# Department of Industry

OUT18/11486

**Altis Warehouse and Logistics Hub (SSD 7173) –  
Environmental Assessment**

Figure 3.2: Zones requiring revegetation in the VMP subject site.

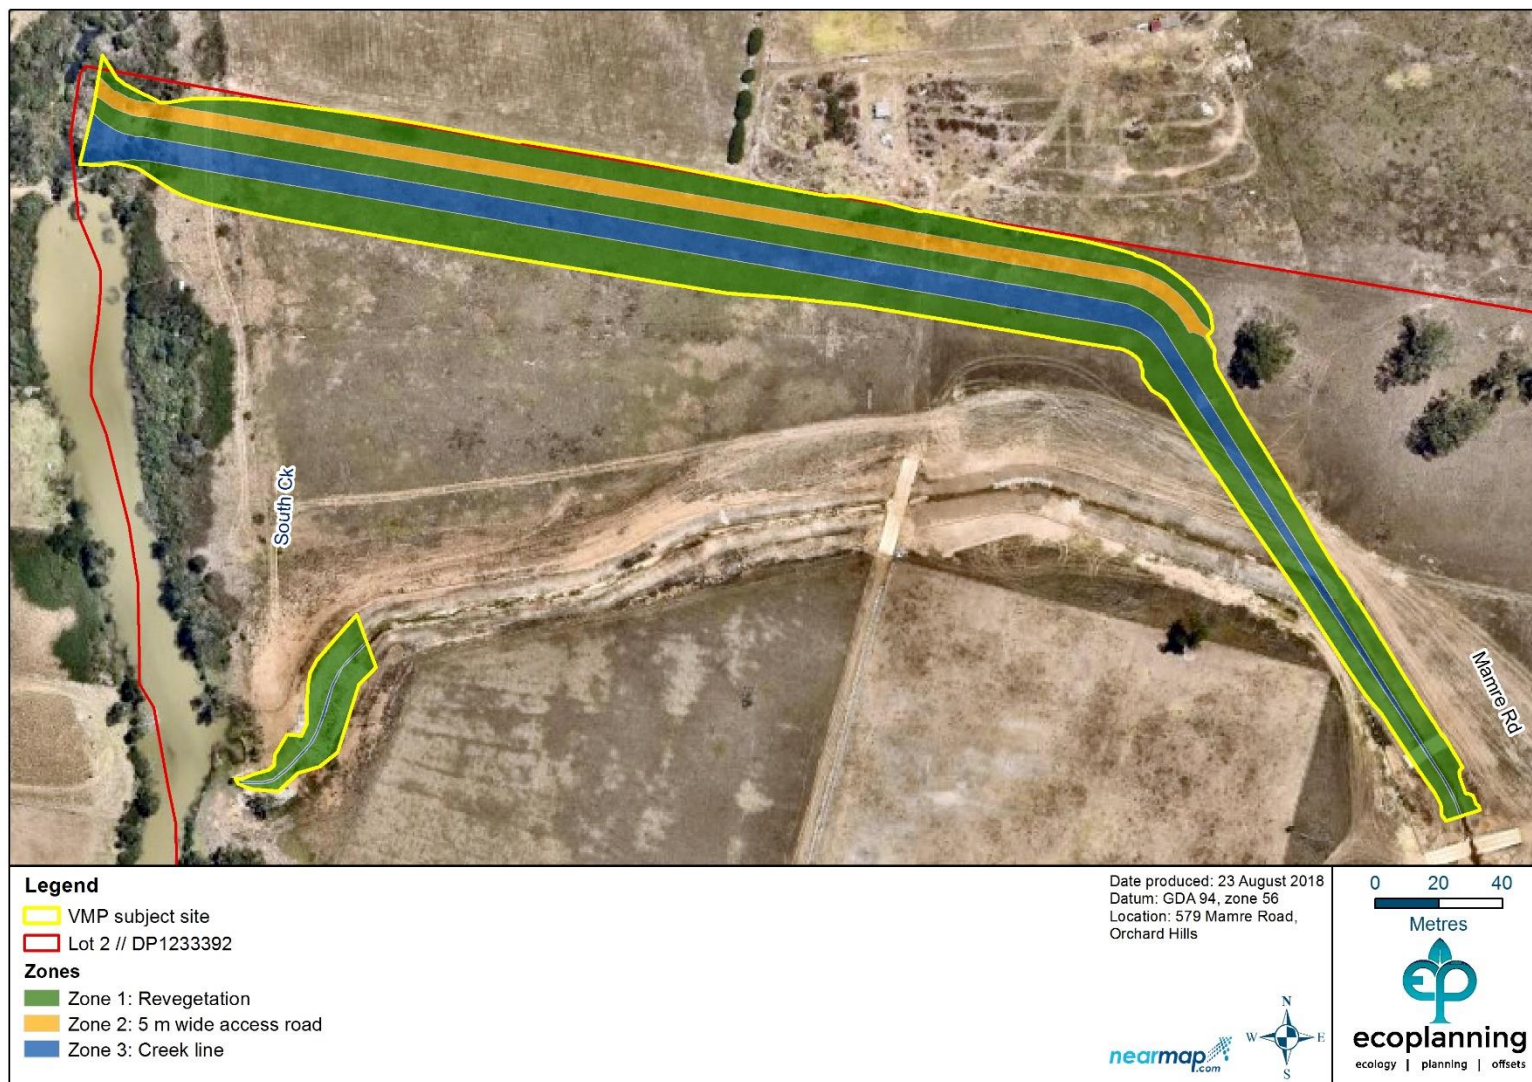
The Department requests that the Vegetation Management Plan is updated to include widths of the Vegetation Riparian Zone in accordance with 'Guidelines for Riparian Corridors' (NRAR 2018).
